RE: **Lot 26 Block 5, S.A.D. 227**
Unser Cliffs Subdivision
8016 Victoria Dr. NW
Grading and Drainage Plan
Engineers Stamp Date; 12-4-18 (E10D055)
Pad Certification Date; No Date

Based upon the information provided in your submittal received 6/14/19, this plan cannot be approved for Pad Certification until the following comments are addressed.

MARTINEZ, ADRIAN (BUILDER: MICHAEL SANCHEZ) - G & D PLAN

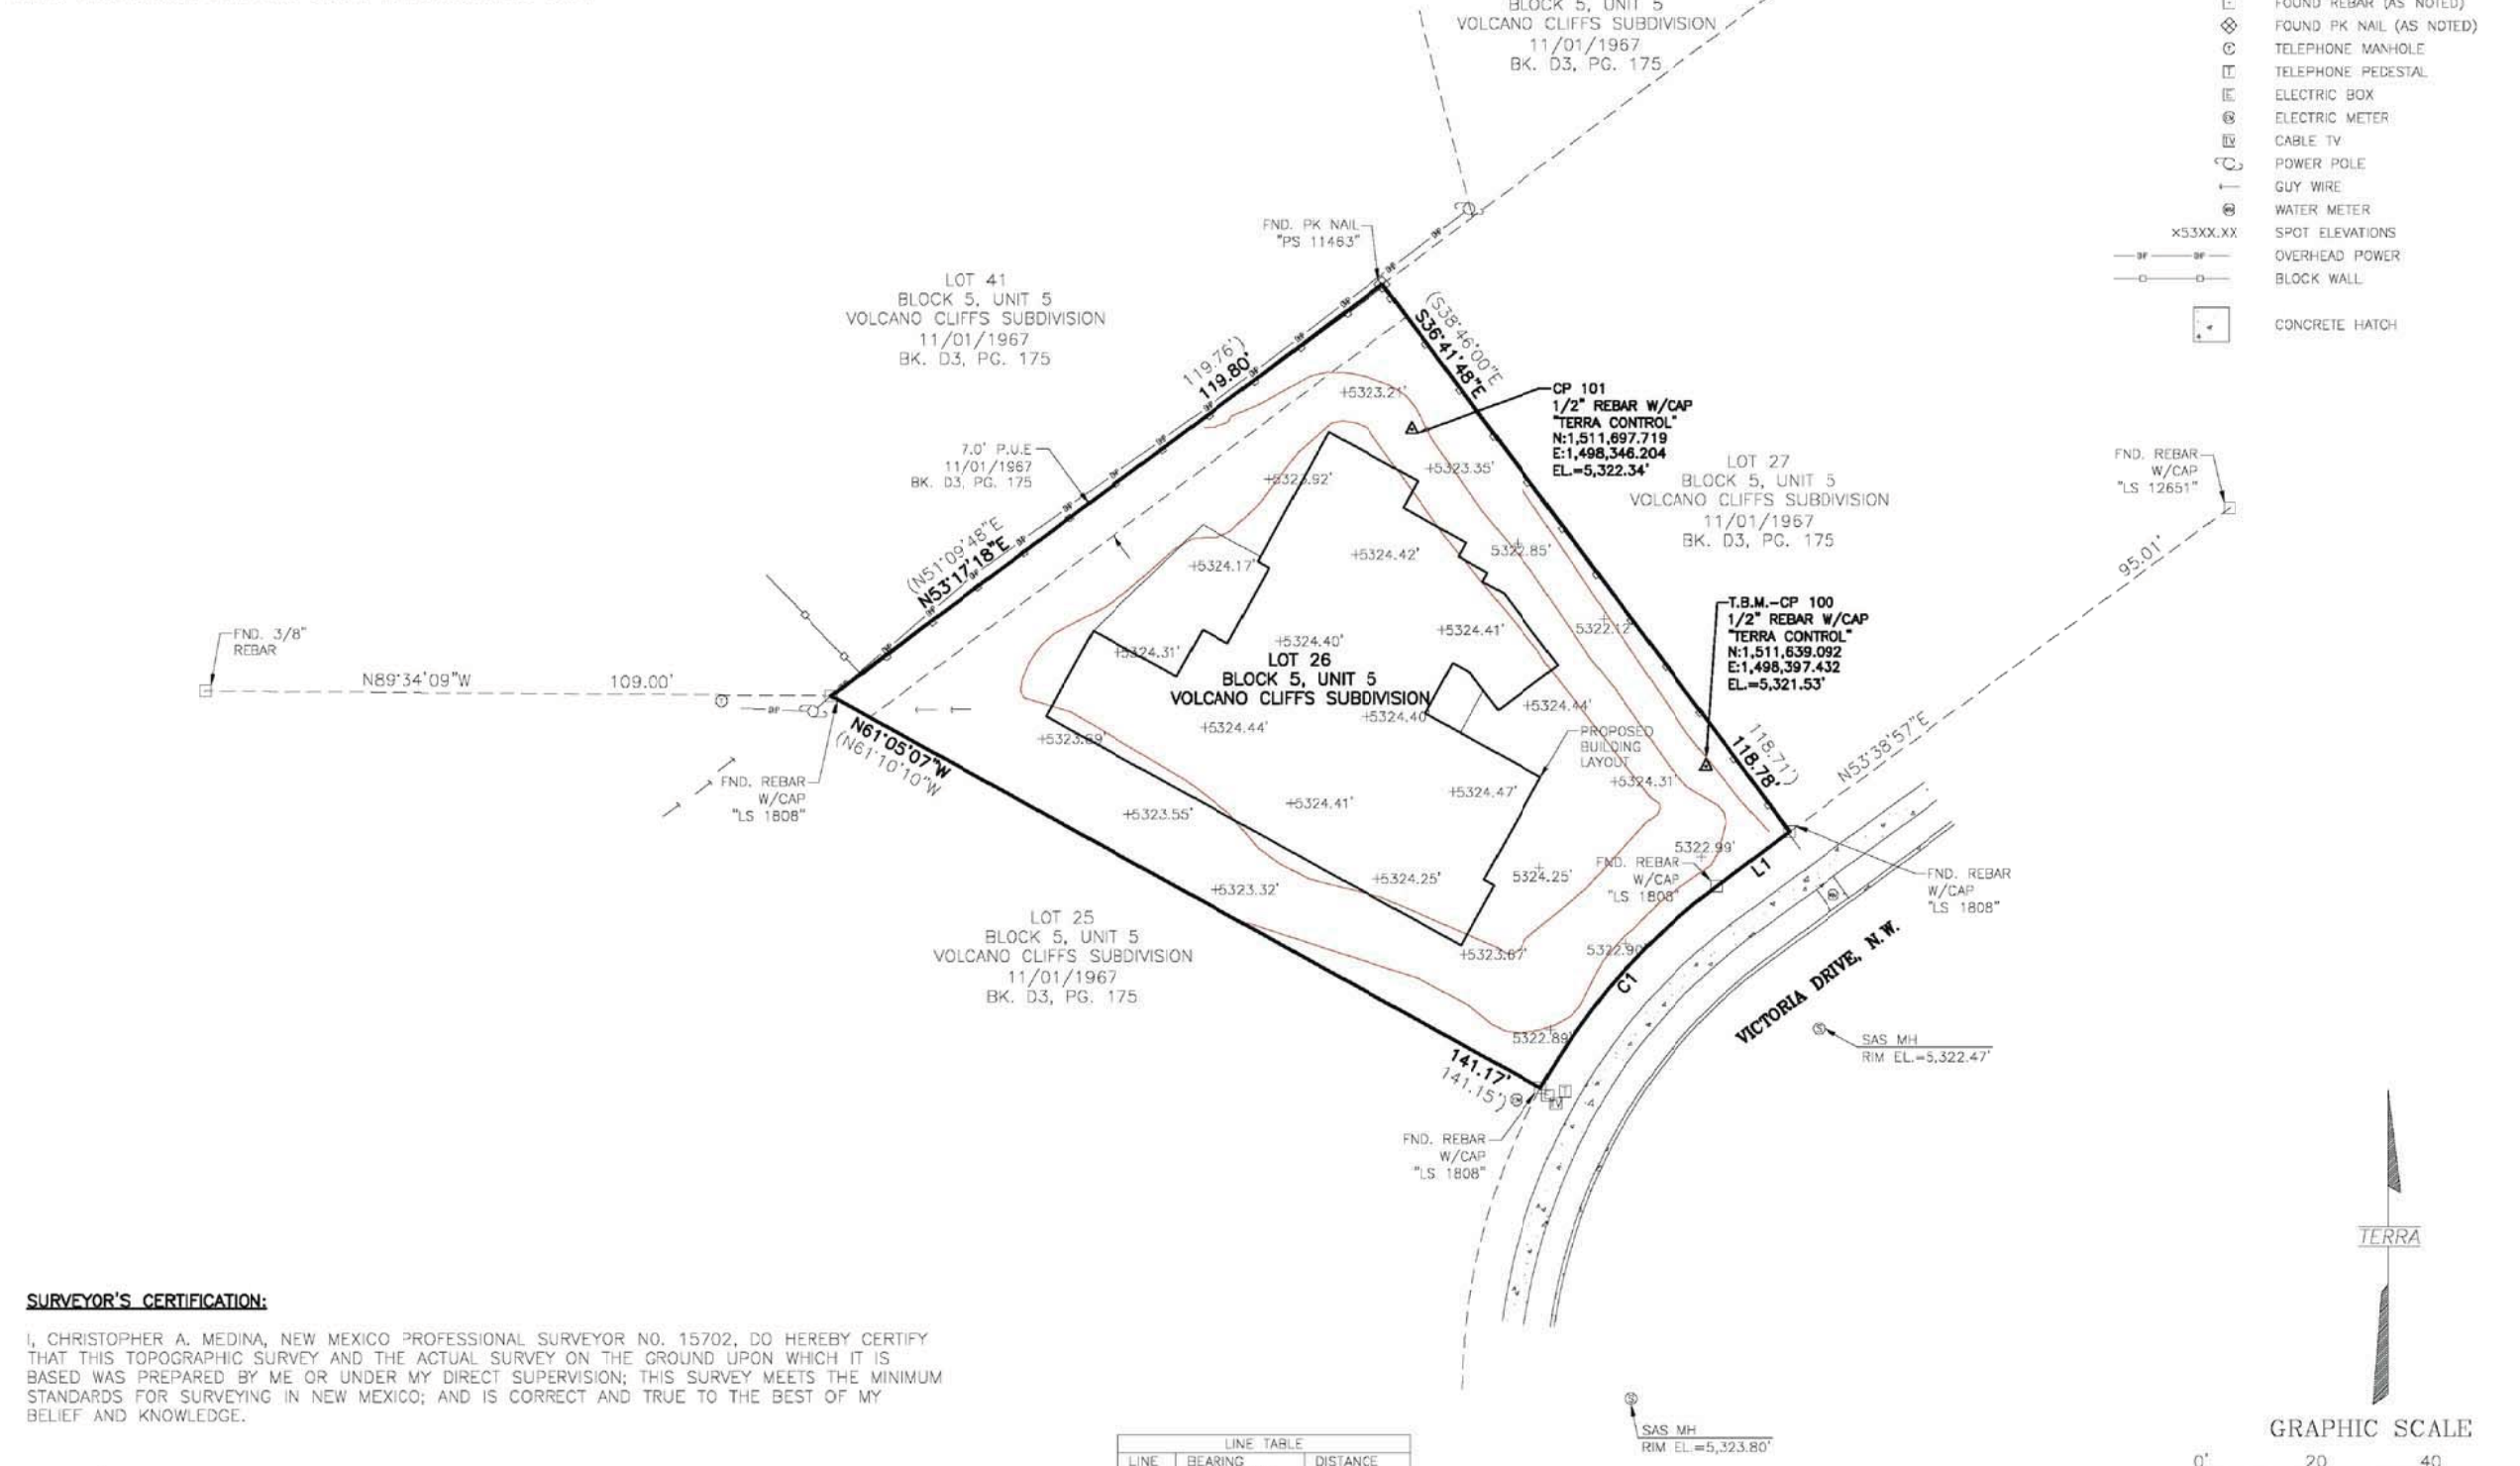
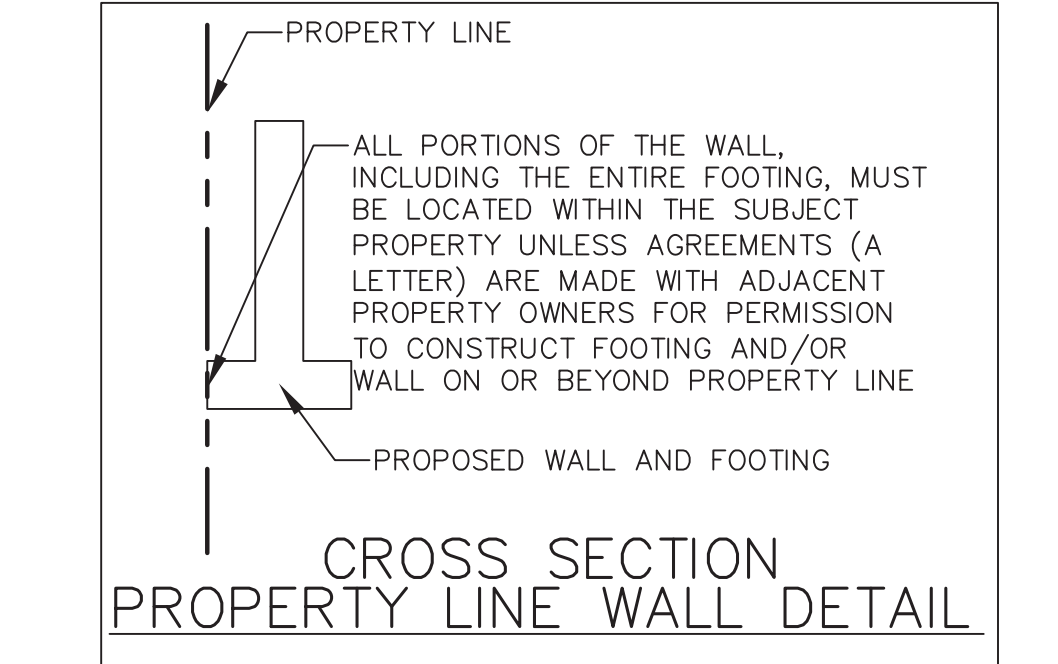
- A date must be provided along with signature in the pad cert box.
- Remove all dirt and debris from the street and sidewalk.
- A pad is not visible, trenches have been dug in the pad for plumbing and footings, once the pad is visible resubmit for pad certification.
